Reference No:	2025/65/90113/E
Site Address:	Providence Place, Bradford Road, Cleckheaton, BD19 3PN
Description:	Listed Building Consent for internal and external alterations
Recommending Officer:	Edward Cheseldine

DECISION – GRANT LISTED BUILDING CONSENT

2025/90113 - Providence Place, Bradford Road, Cleckheaton, BD19 3PN

DRAWING NO.: C/24/004/A
 SCALE: 1:25/1:50 @A1
 DATE: 11/9/24
 DRAWN BY: Russ Connolly

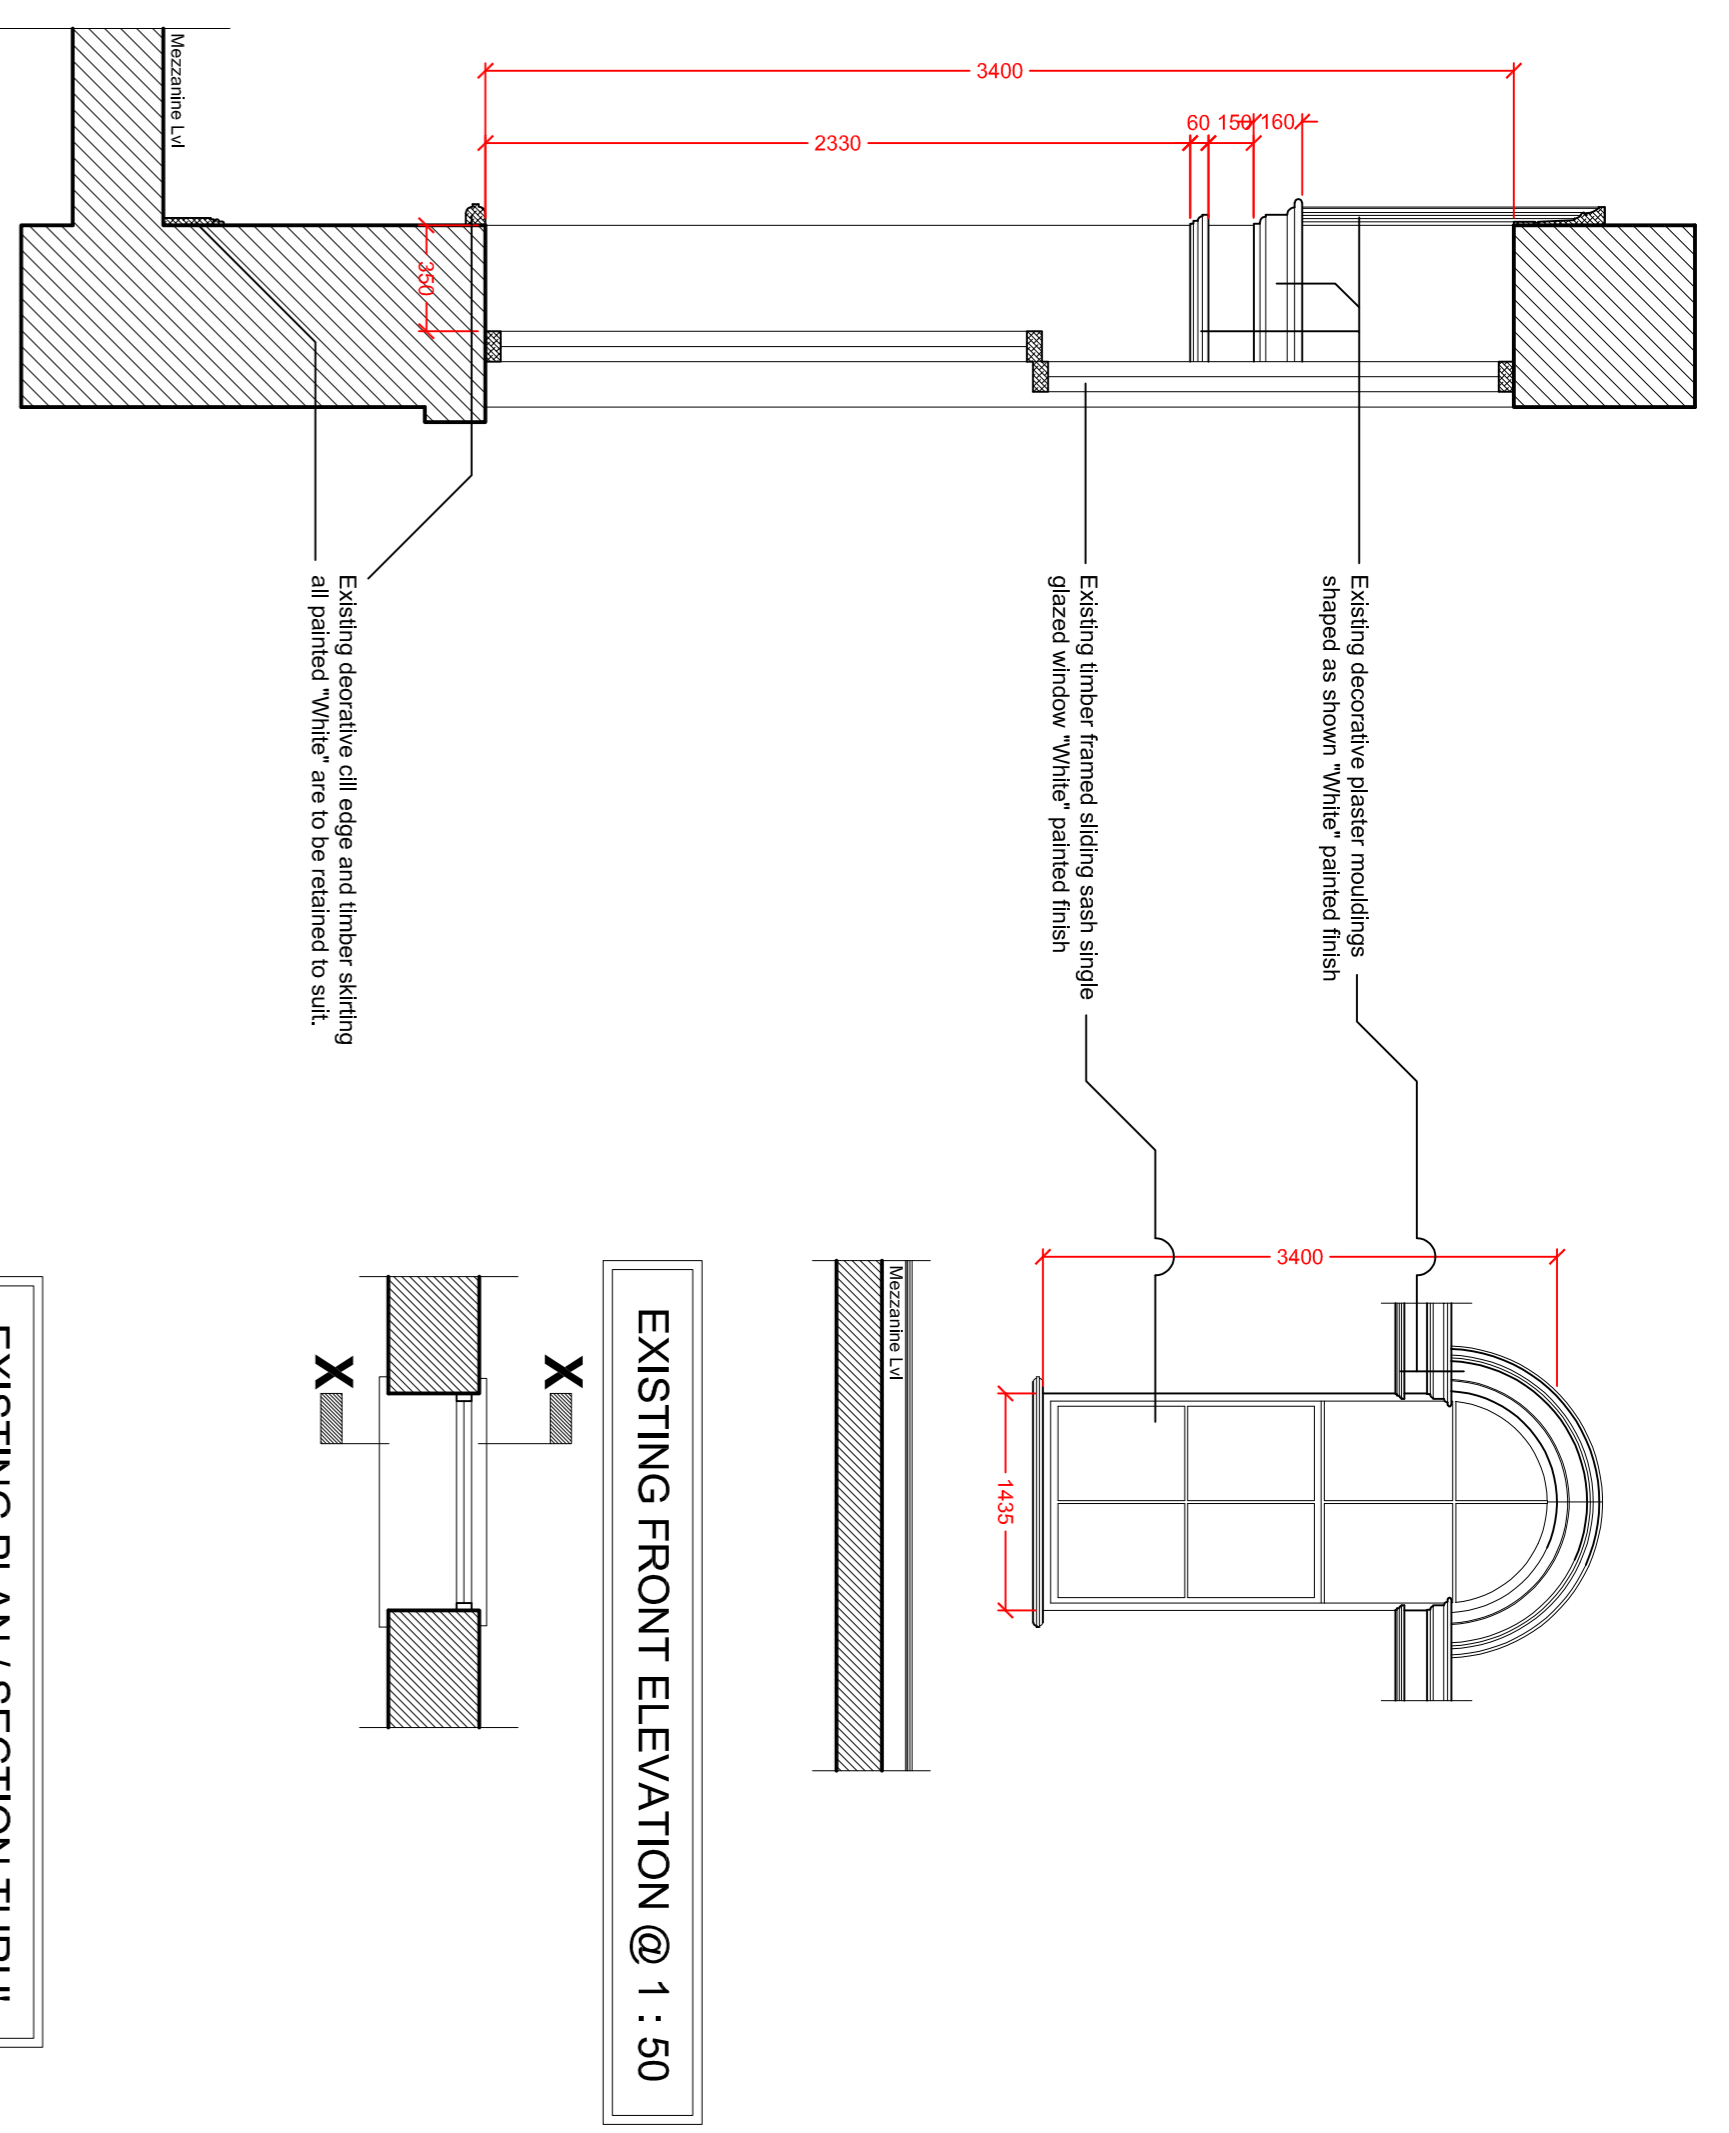
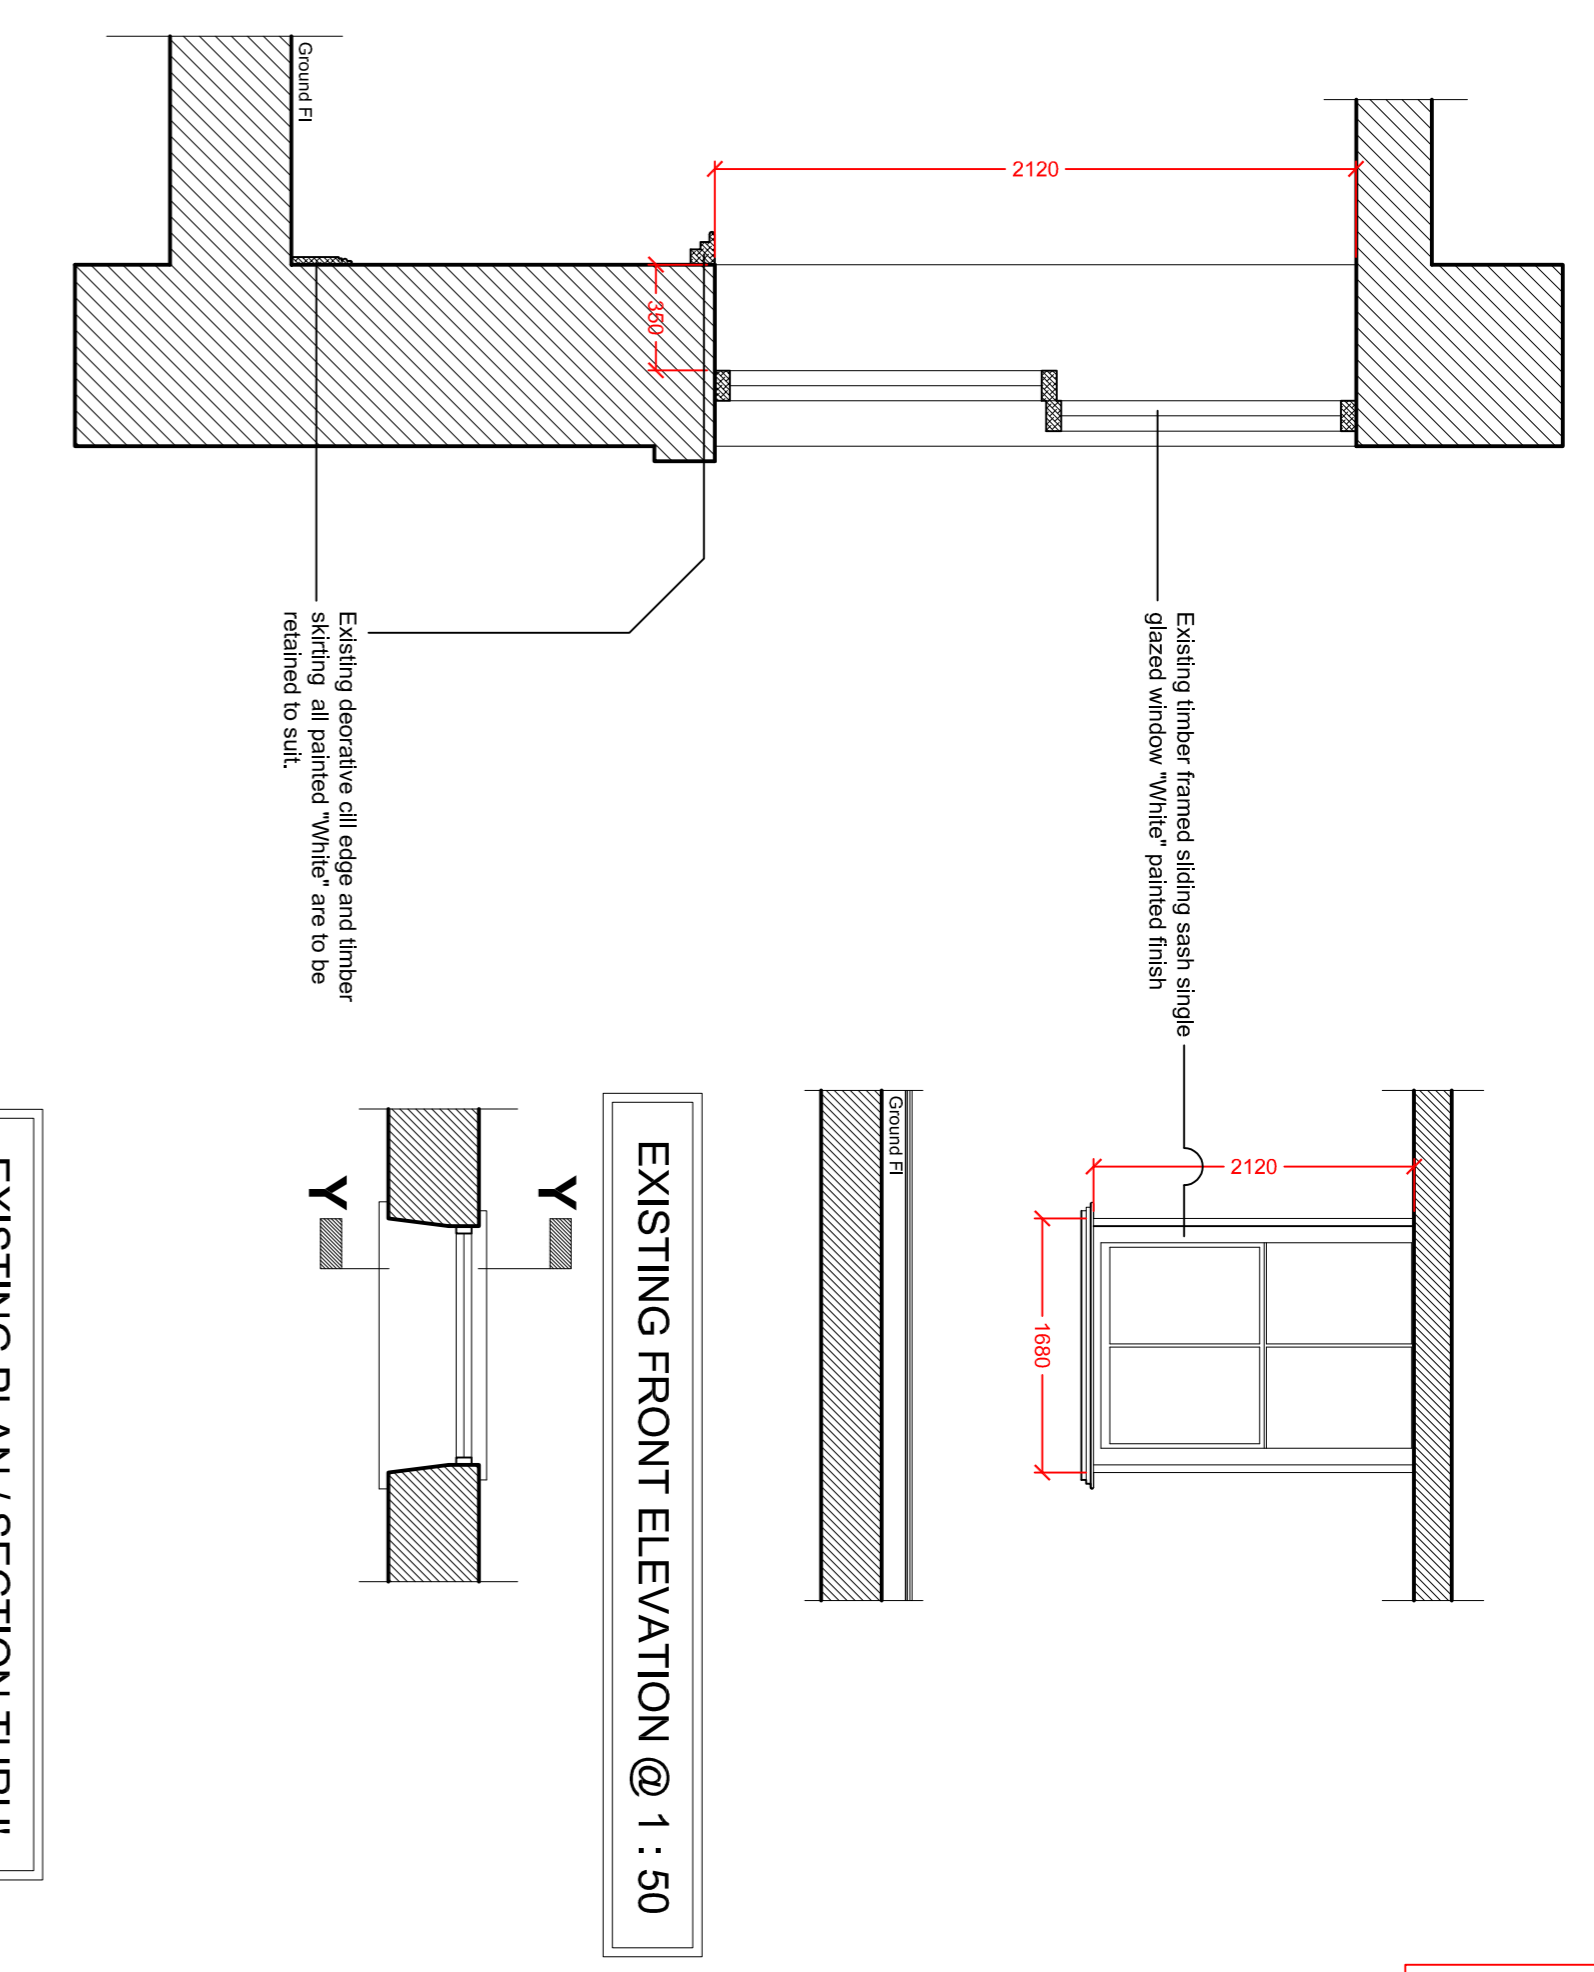
Secondary glazing is being installed to improve the thermal efficiency. Windows in place are original. The secondary glazing will have aluminium frames, single glazing in sliding sash style, set 100mm from existing sash windows. They will be fixed to fret cut timber sections to avoid removal of original plaster work. Glazing bars and colour scheme match with the original windows.
